**From:**  
**Sent:** 28 December 2024 13:23  
**To:** DC Admin; Joanna Rednall; Cllr Jo Lawson;  
**Subject:** planning application 2024/62/93007/W – 67a Crosland Hill Road

**Planning application 2024/62/93007/W – 67a Crosland Hill Road, Crosland Hill, Huddersfield, HD4 5NZ.**

DRAWING TITLE
**PROPOSED FIRST FLOOR/ROOF AND
BLOCK PLAN**

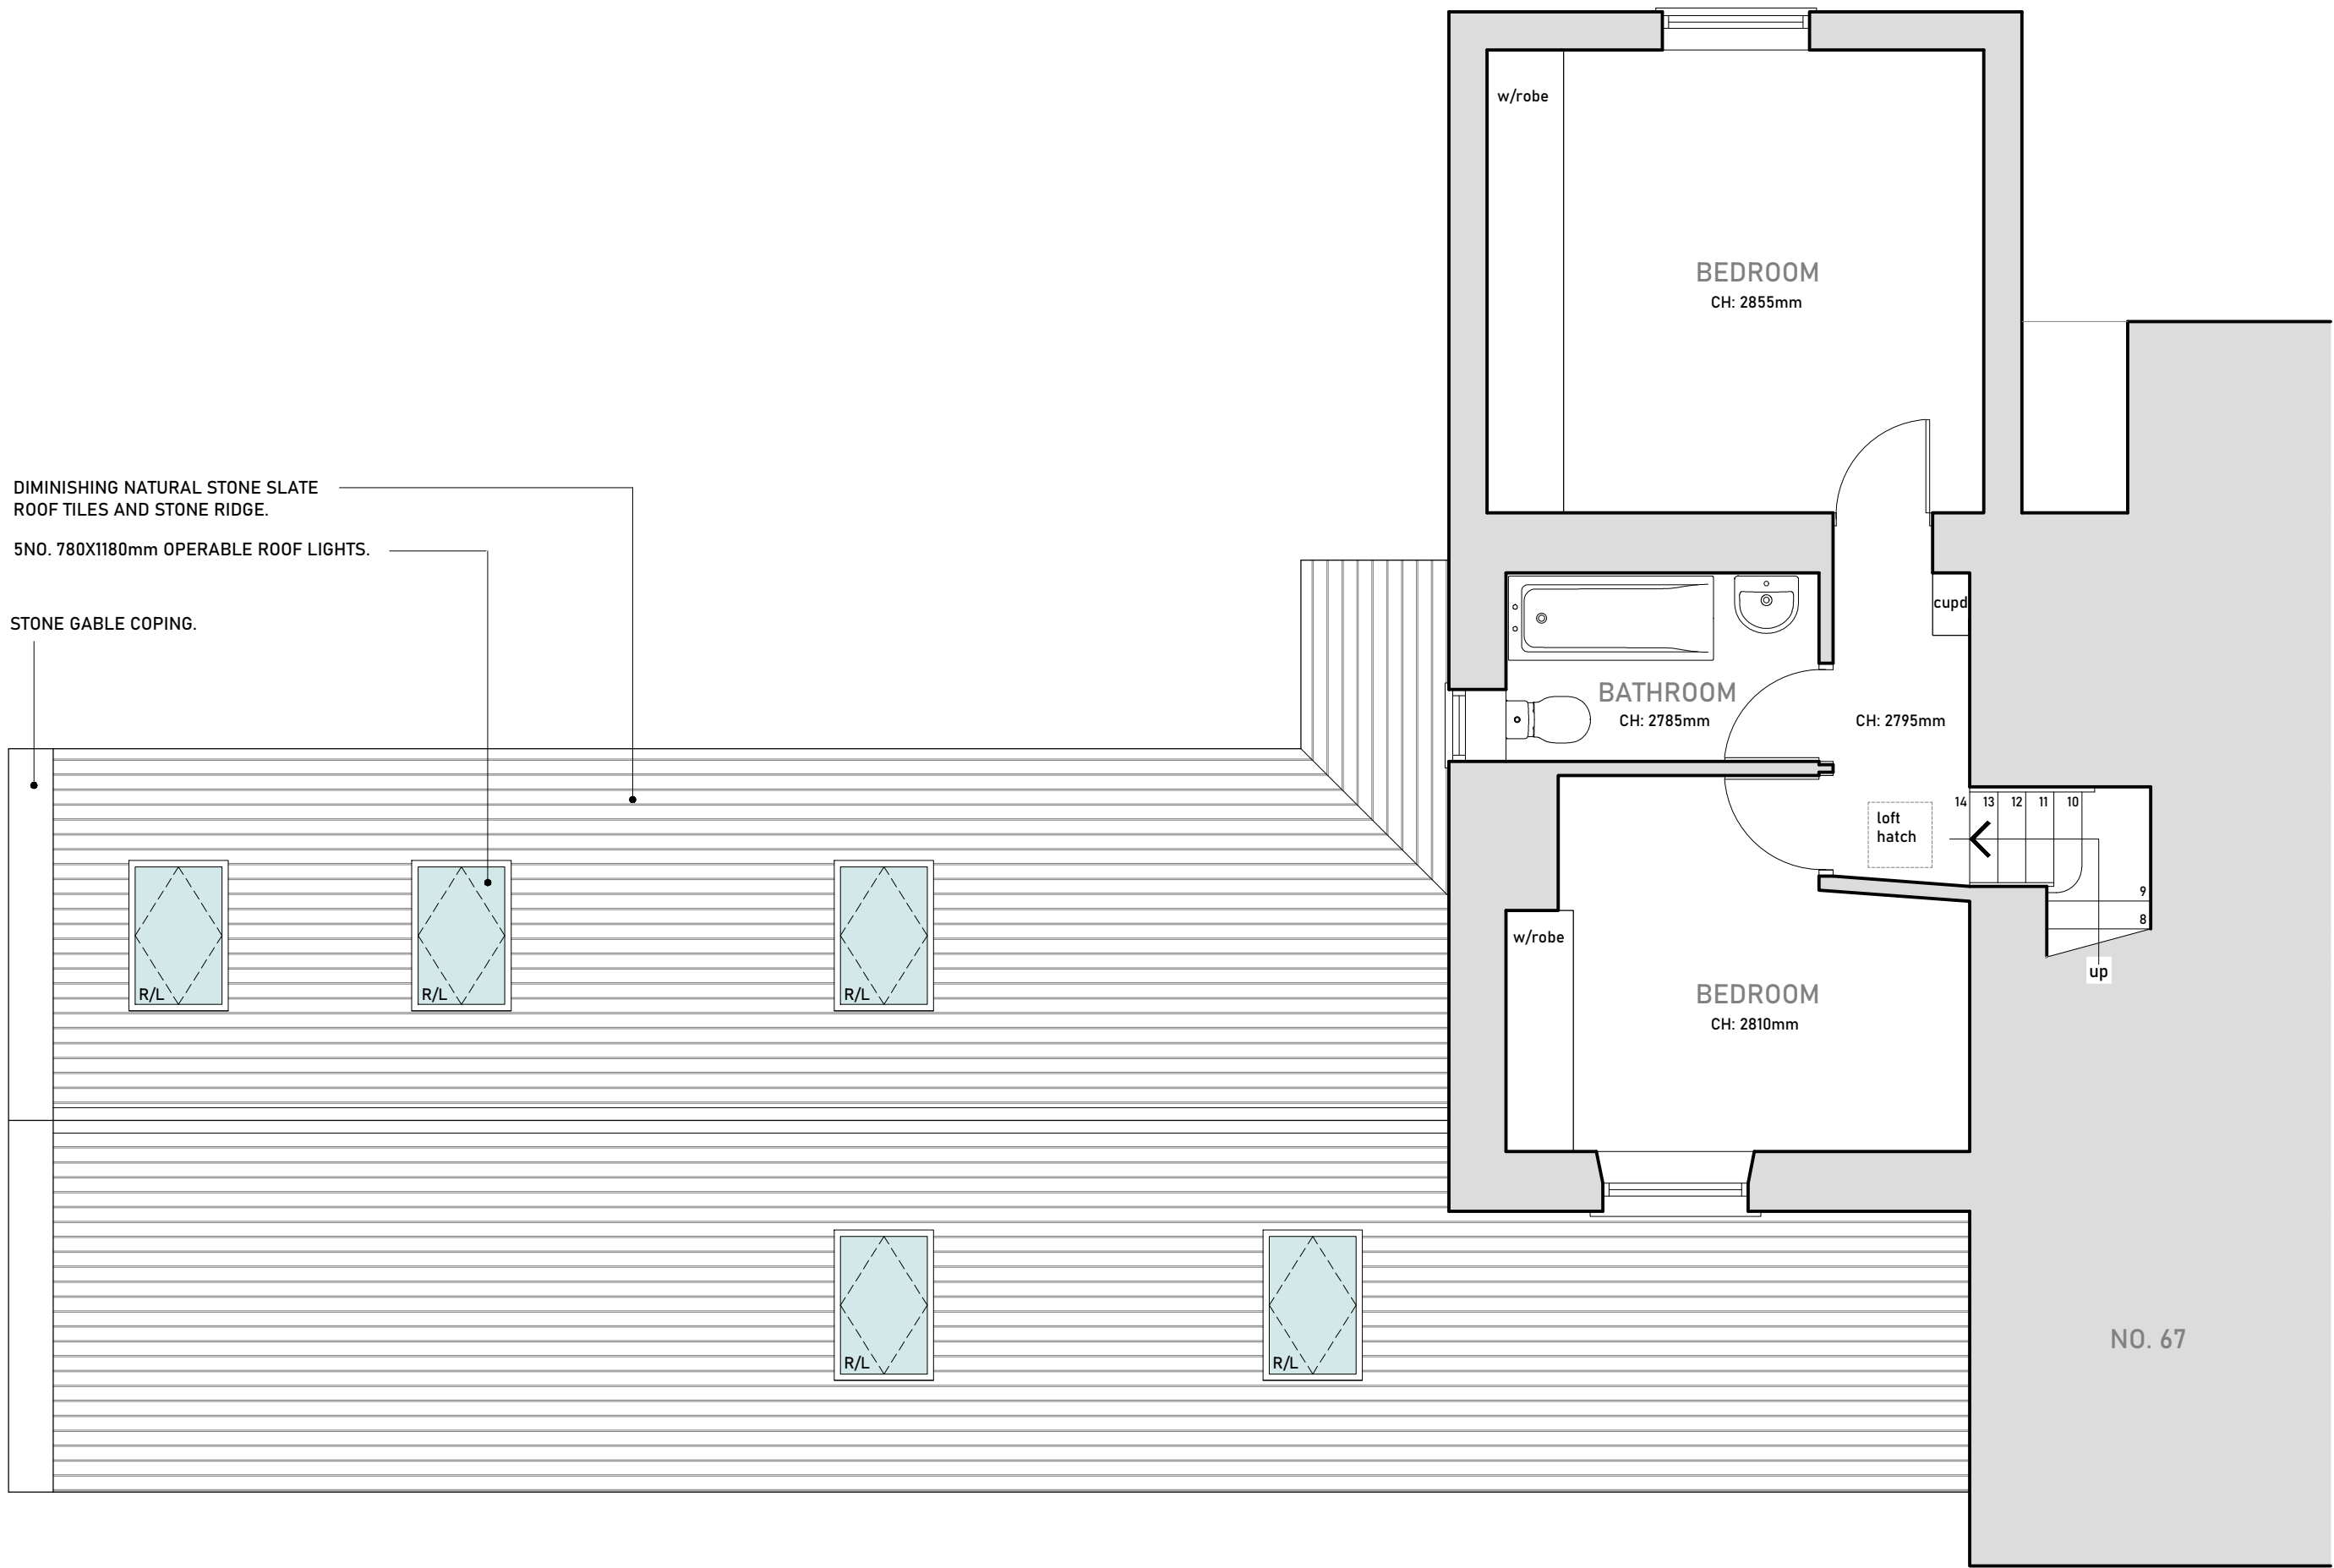
**What the building or development will look like:** This extension is far too large for the site, almost double the size of the existing house as well as being built on land that is negotiable for ownership. The shared driveway/lane is a right of access for all four houses. The planning application suggests this is sole ownership to number 67a which is factually incorrect.
